extending Homes
'Larkfield'
Yapton Road
Barnham
PO22 0AY

Our Ref: AW/331/21/NMA

Non material amendment following the grant of AW/200/21/HH for dormer fronts to sit on front wall plate.

47 Lincoln Avenue Aldwick PO21 3EW

Proposed North Elevation

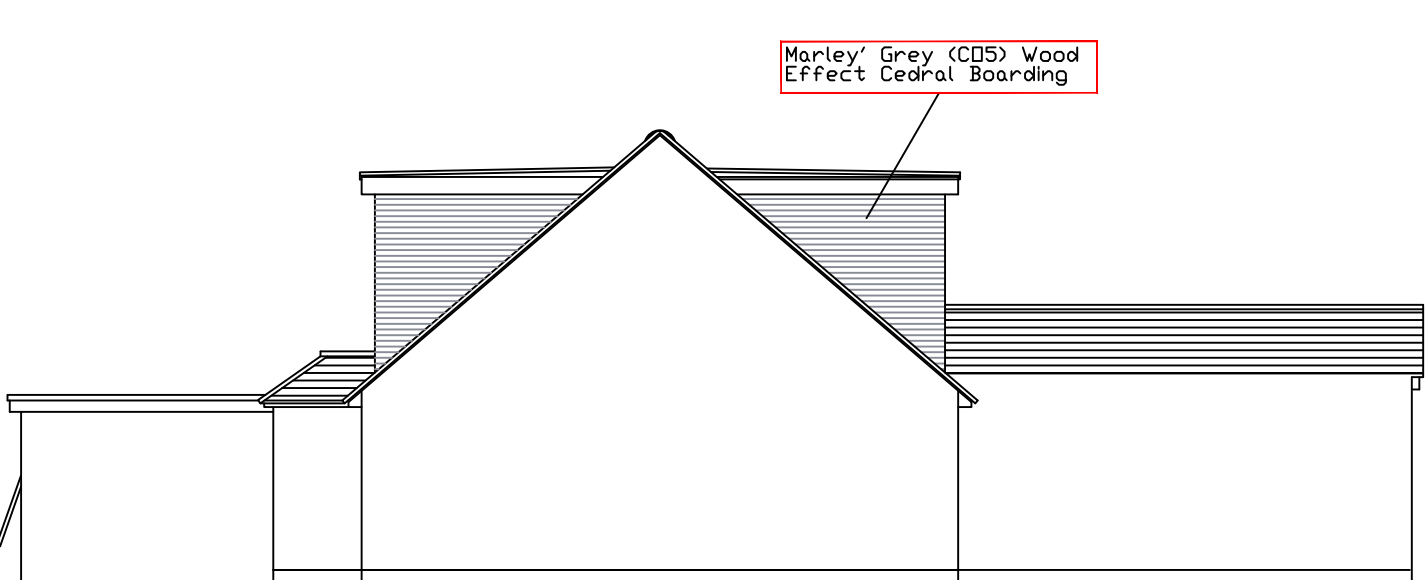
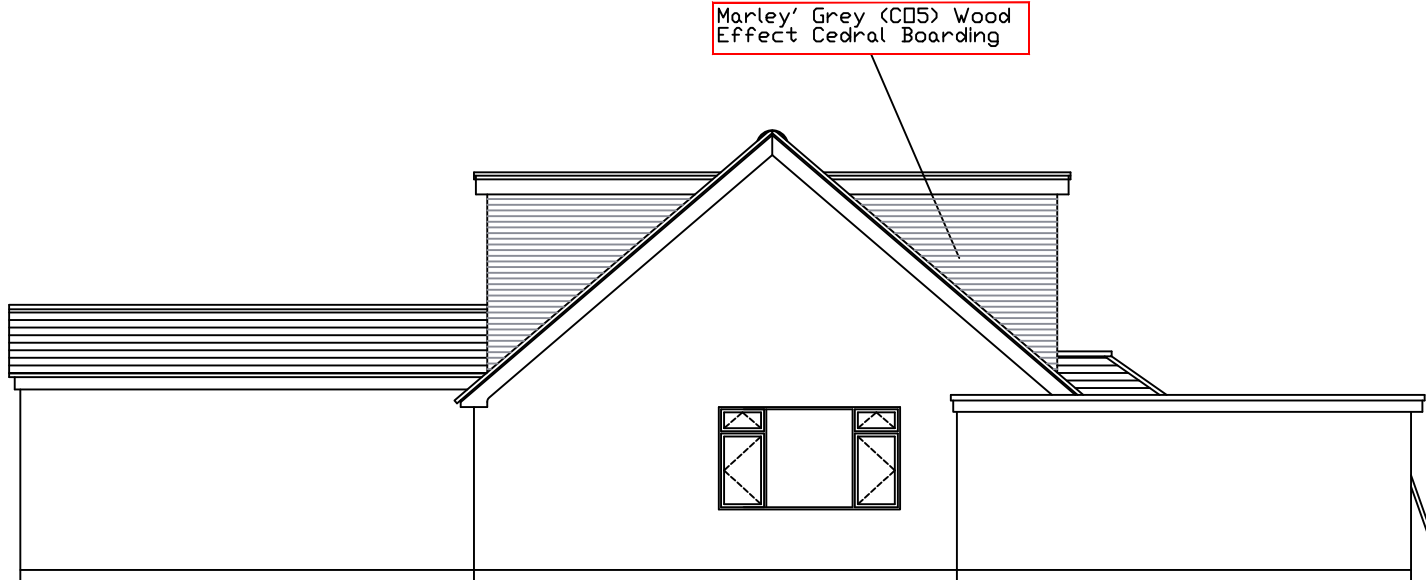
I refer to your recent application for a Non Material (minor) Amendment following approval of AW/200/21/HH. You have stated that you made an error in the original submission in that the approved proposed floor plans drawing shows the front dormers off the internal wall plate as per all the other dormers in Lincoln Avenue but that the approved north and south flank elevations show the dormer set back from the wall plate.

I note that the front dormer is shown on the new plans as extending further forward by approximately 0.7m and now matches with the approved first floor plan. However, in any case, this difference is within the above the stated tolerances.

Drawings 2021063/PL/2 Rev A Floor & Roof Plans and 2021063/PL/1 Rev B Elevations therefore replace the equivalent drawings approved by AW/200/21/HH.
